Re: Objection to MP08\_0244 MOD 1 Modification Request for Mixed Used Development at 23-37 Lindfield Avenue and 11 Havilah Lane, Lindfield

As a resident of Lindfield, I/we wish to lodge an objection against the proposed Modification of the subject development based on the following grounds:

3 SHADOW DIAGRAM - 21stDEC_3PM
5003 SCALE1 : 650

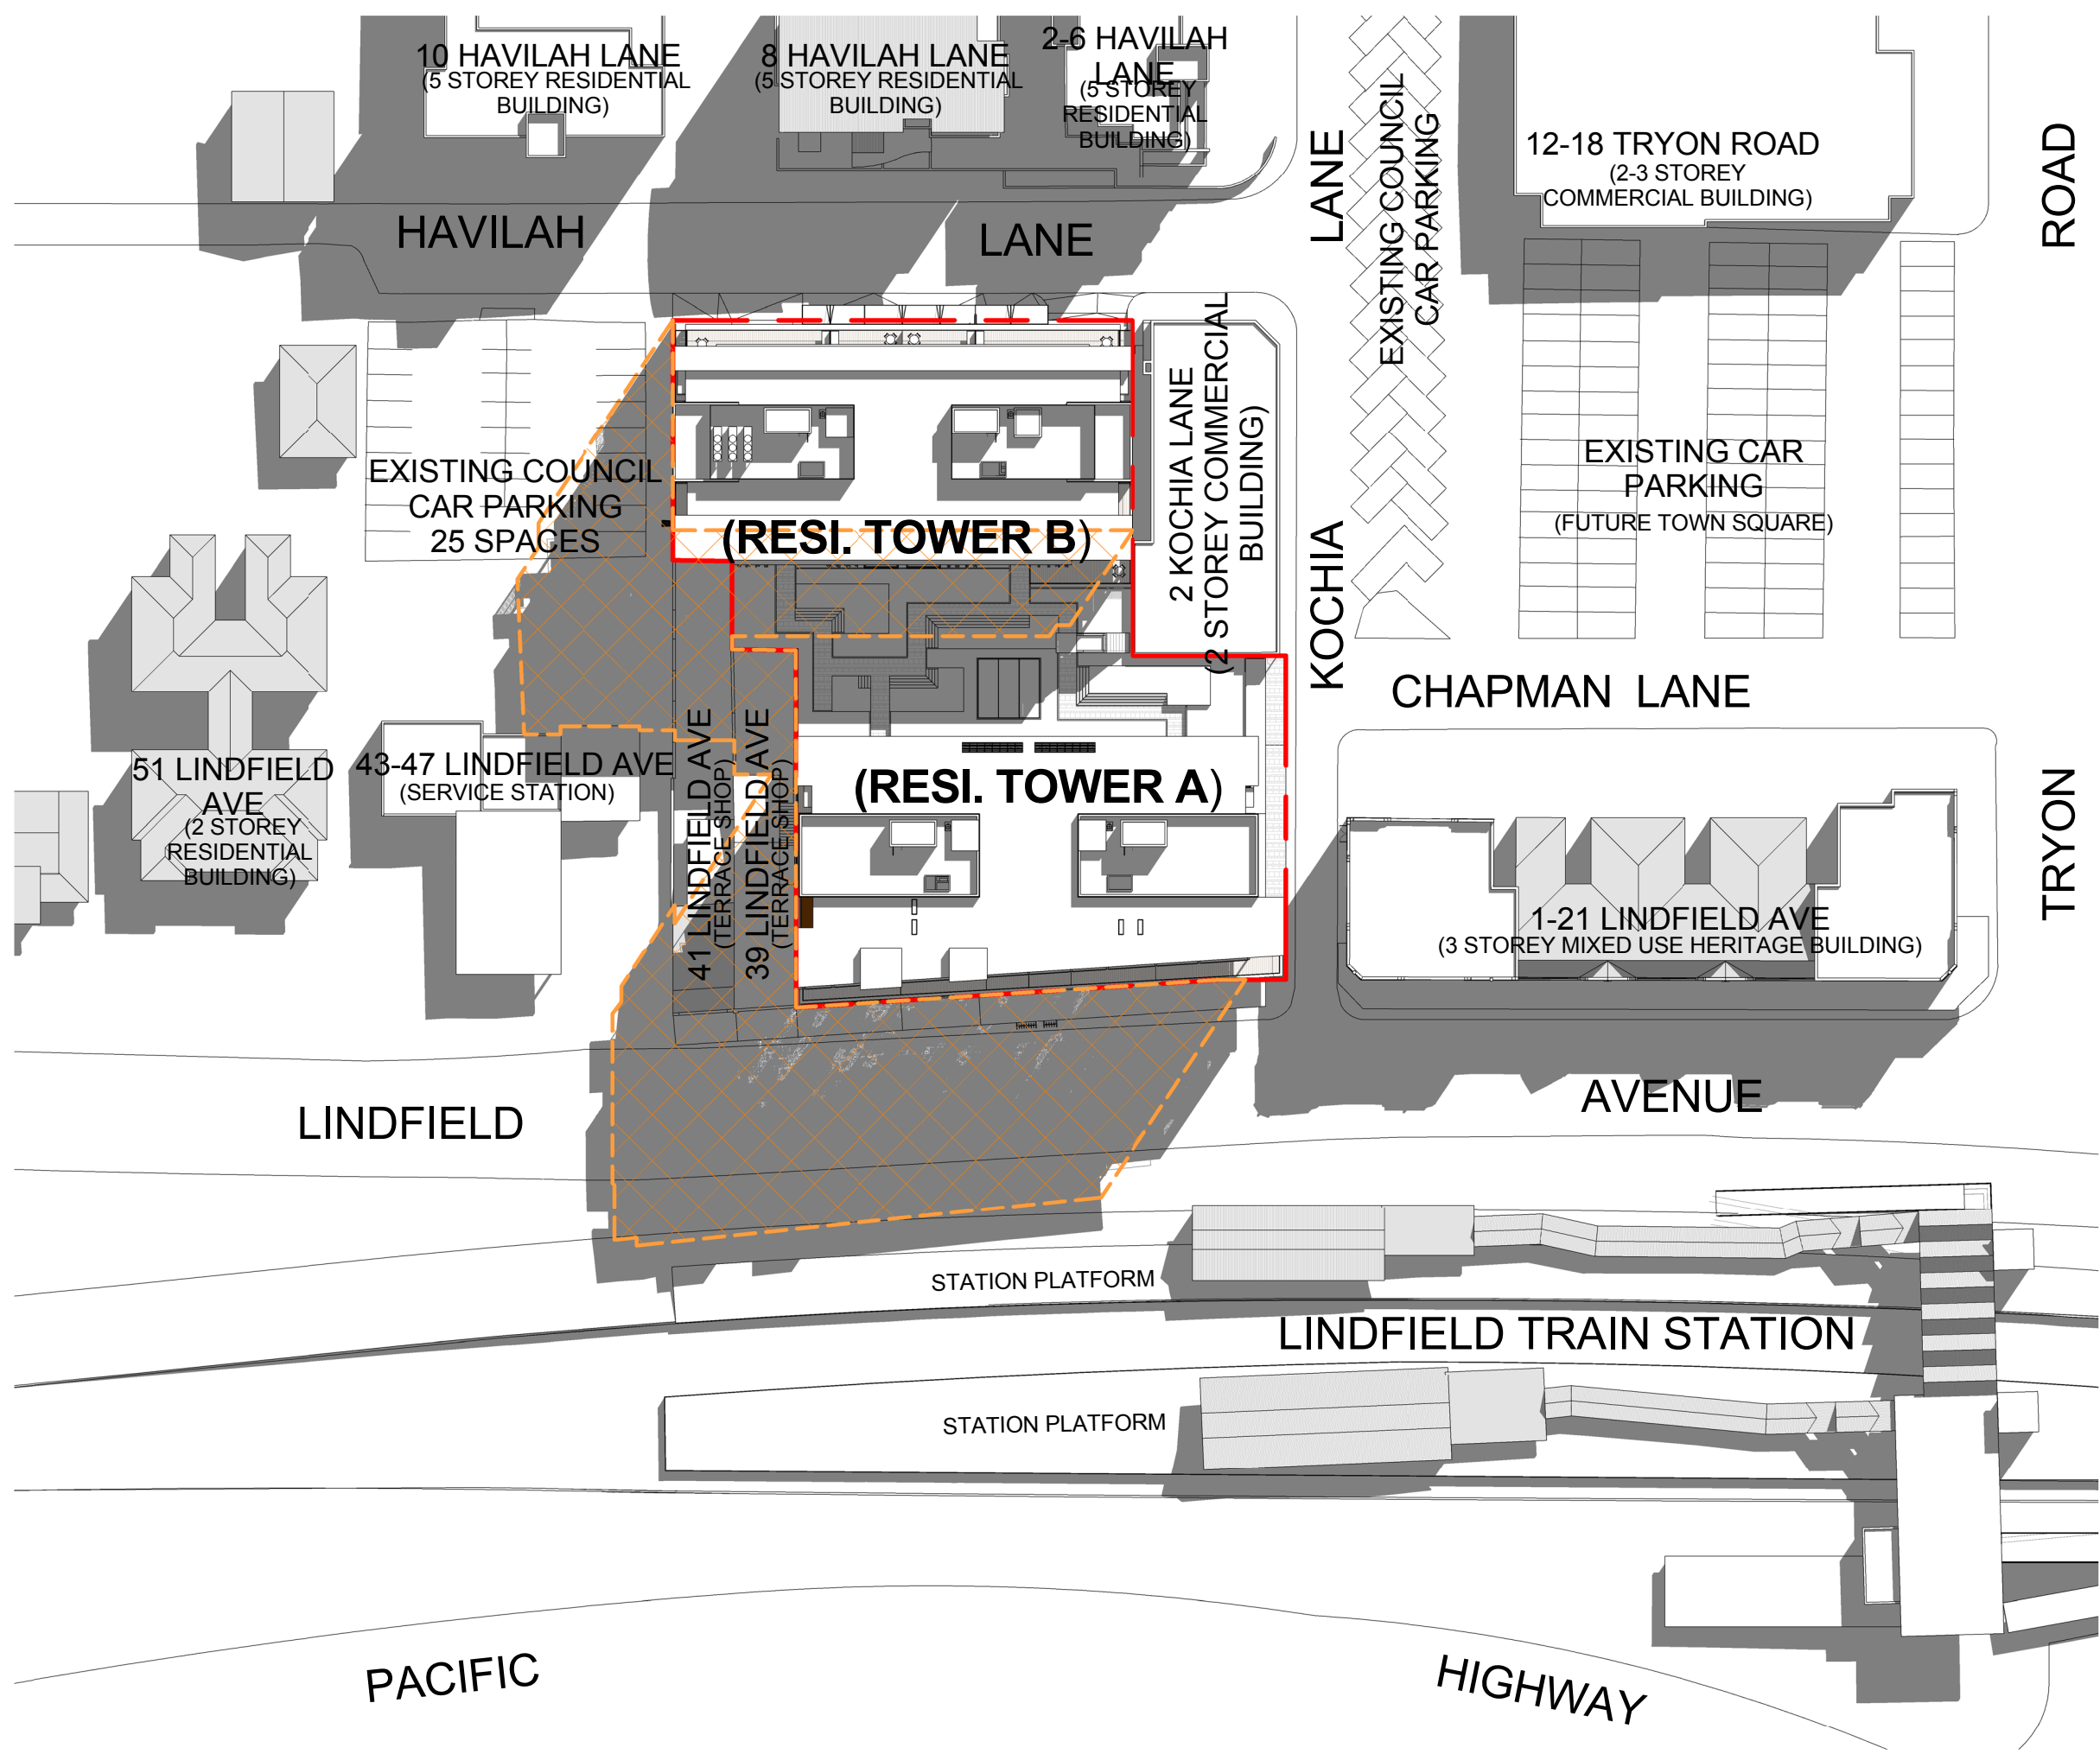
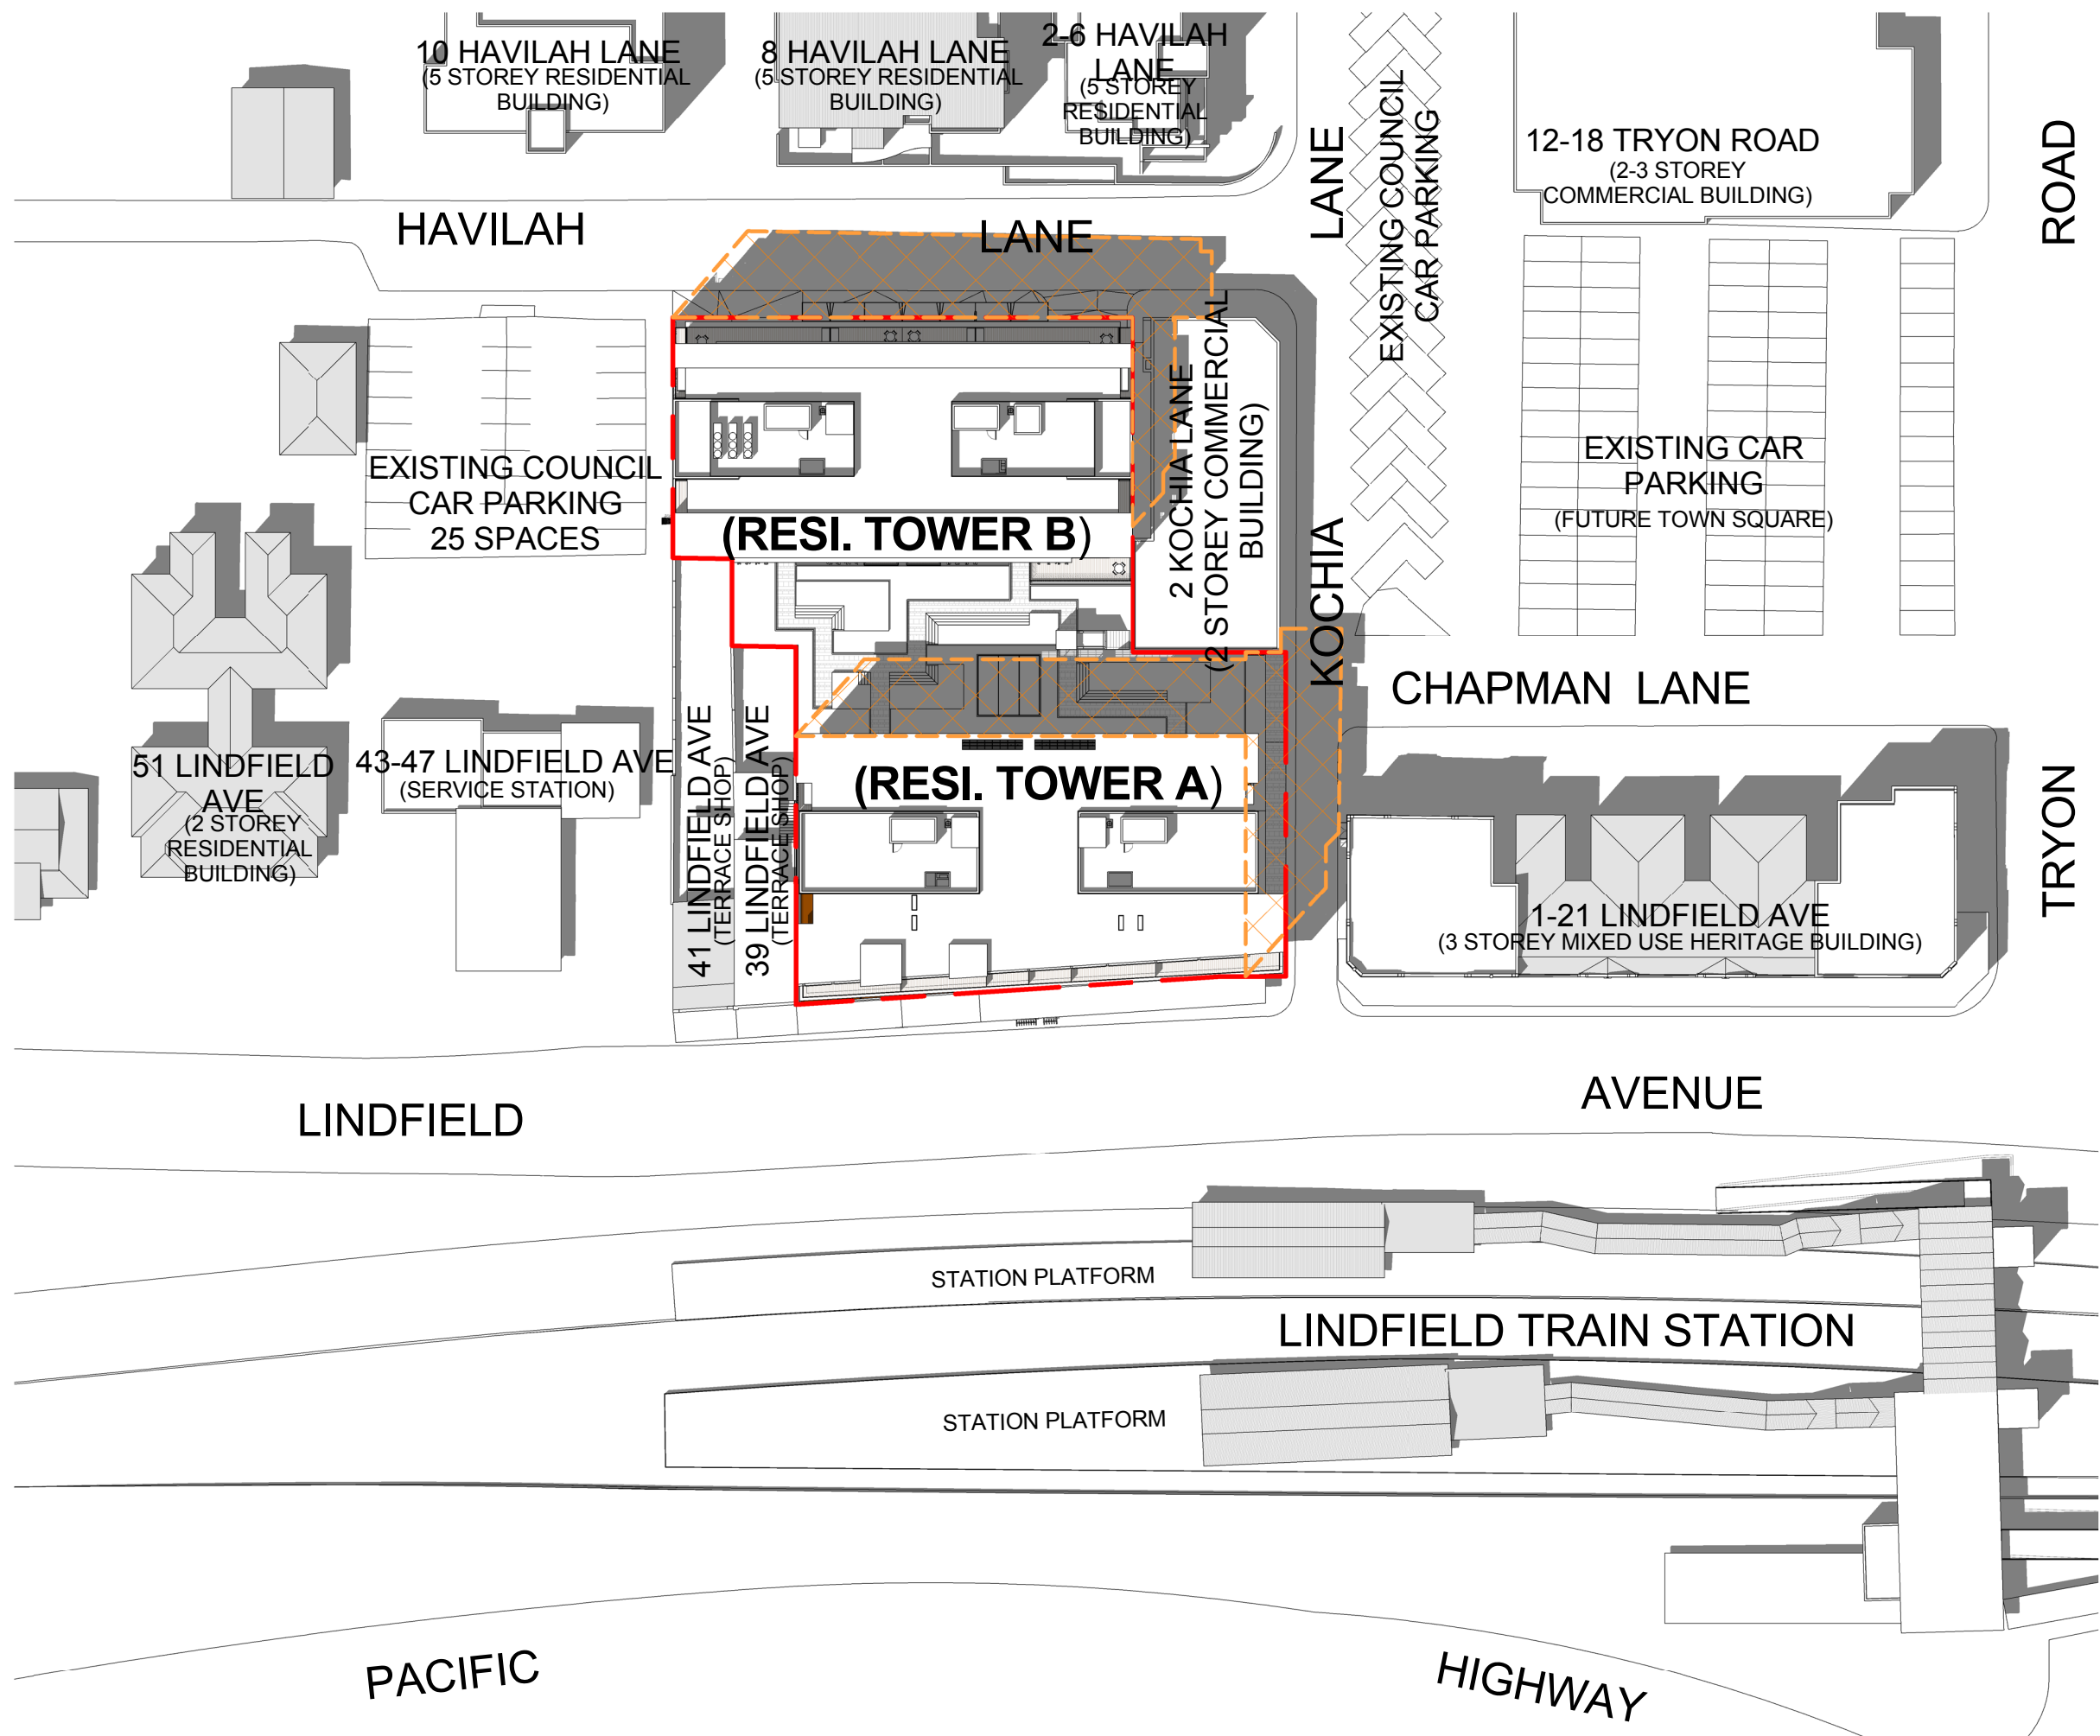
- The additional storeys create new adverse shadowing: a) for residents in the Havilah Lane apartments, particularly after 3pm b) for the popular outdoor café and central Lindfield hub area at 12 Tryon Road in afternoons, particularly in winter and c) for all commuters on the city bound Lindfield rail platform, instead of 50% of the year as approved, it will now be in shadow in the mornings 75% of the year
